Fire Marshal Division

RE: Ed's Restaurant Expansion
53 E. Depot St.
Angier, NC 27501

Application Number – FMFW1904-0005

DESCRIPTION:  
**Ed's Family Restaurant**  
 43 E Depot St, Angier, NC 27501

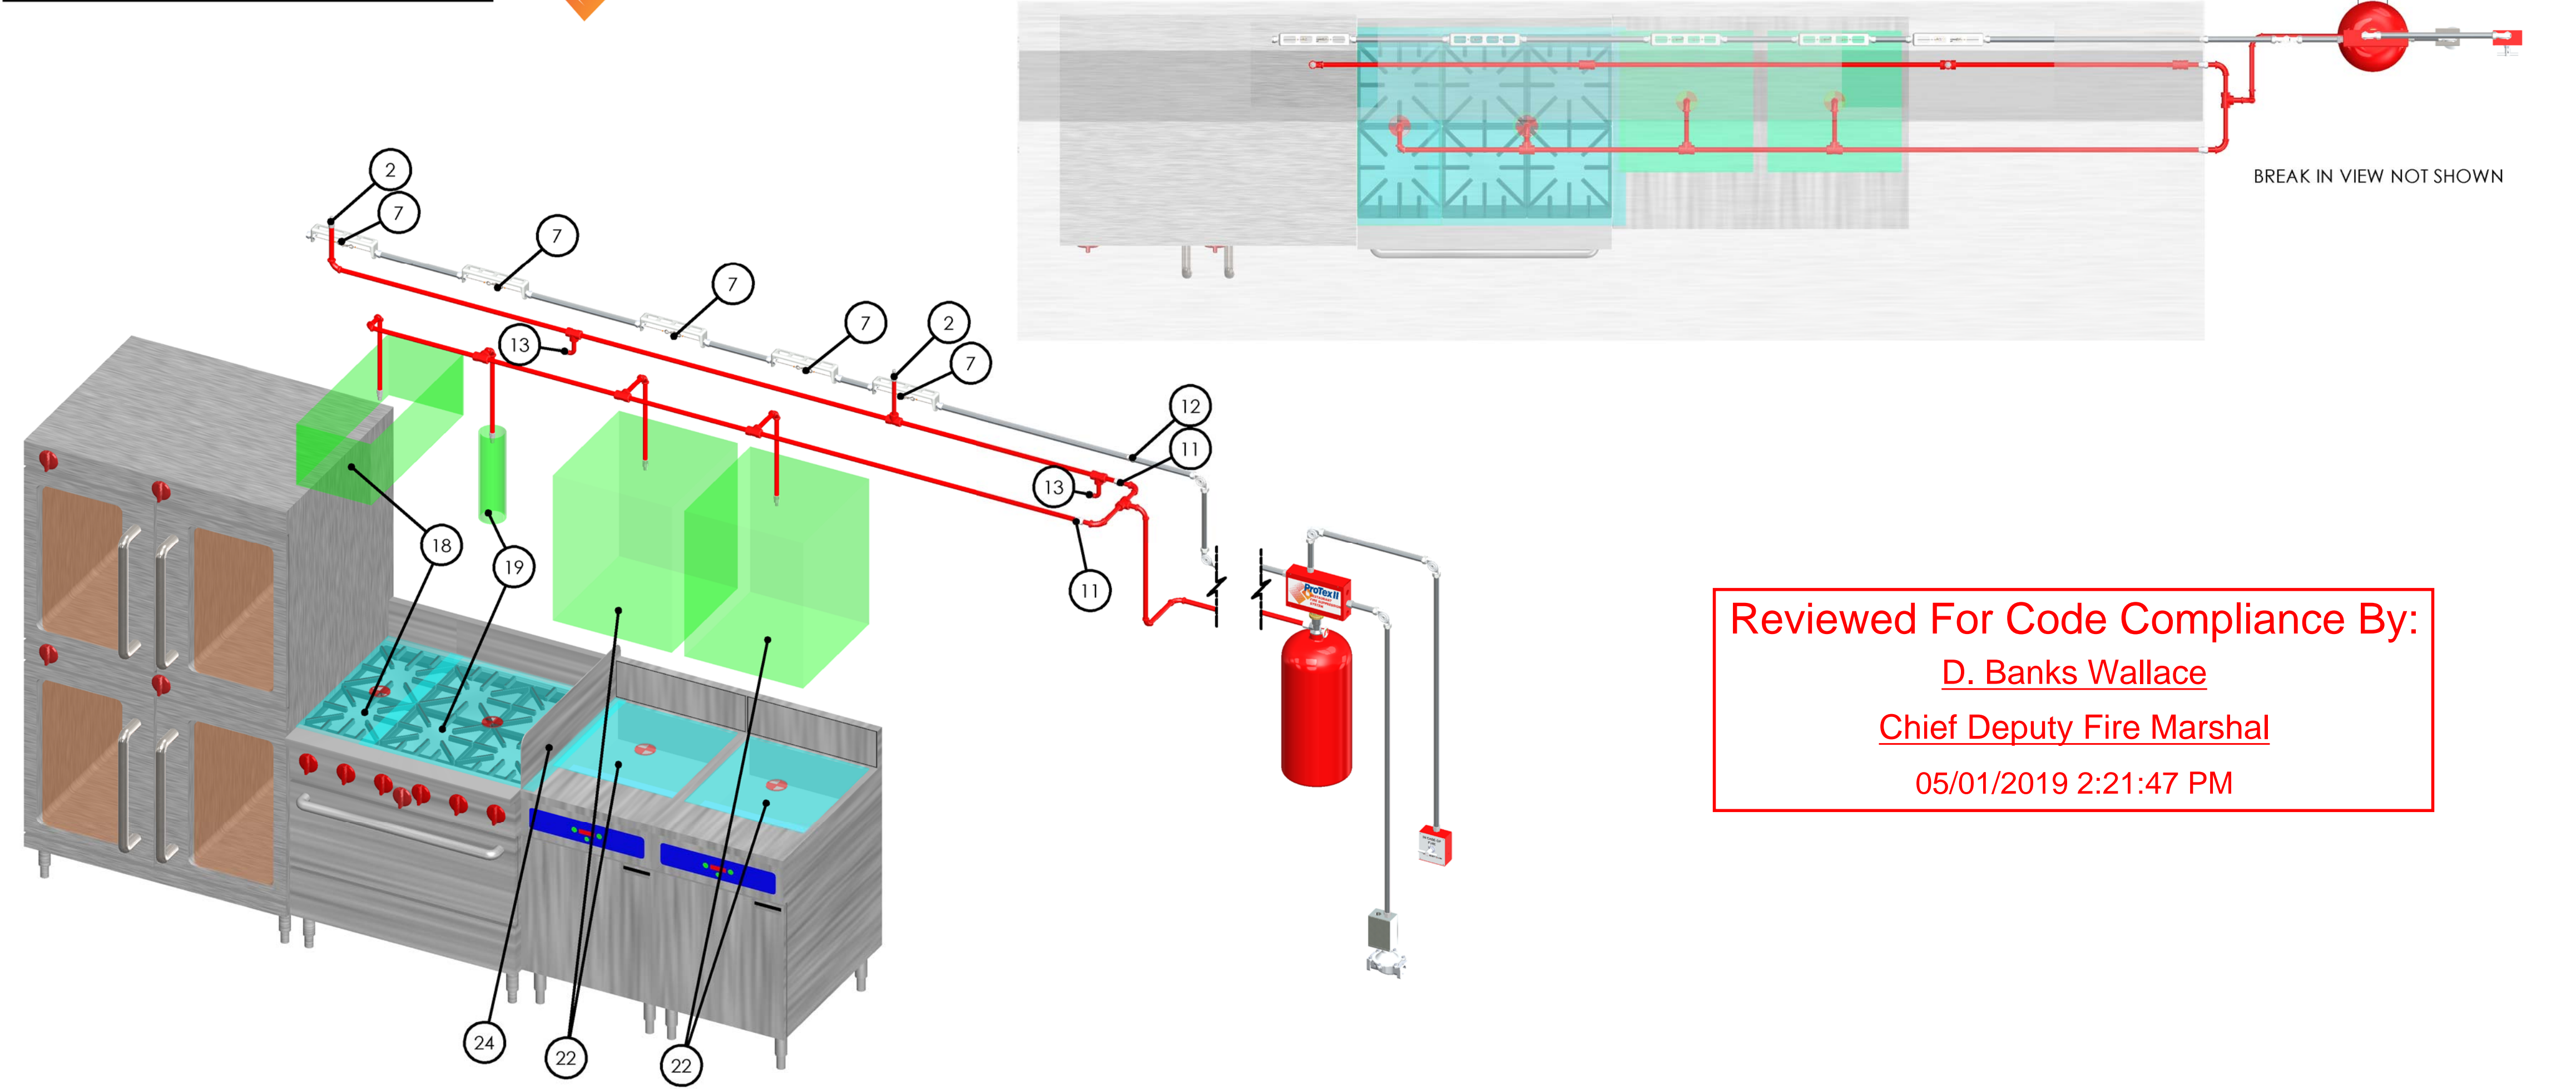
- **904.12.1 Manual system operation of Commercial Hood System**
 - A manual actuation device shall be located at or near a means of egress from the cooking area, a minimum of 10 feet (3048 mm) and a maximum of 20 feet (6096 mm) from the kitchen exhaust system. The manual actuation device shall be located a minimum of 4.5 feet (1372 mm) and a maximum of 5 feet (1524 mm) above the floor. The manual actuation shall require a maximum force of 40 pounds (178 N) and a maximum movement of 14 inches (356 mm) to actuate the fire suppression system.

- **904.12.2 System Interconnection of Commercial Hood System**
 - The actuation of the fire suppression system shall automatically shut down the fuel or electrical power supply to the cooking equipment. The fuel and electrical supply reset shall be manual.
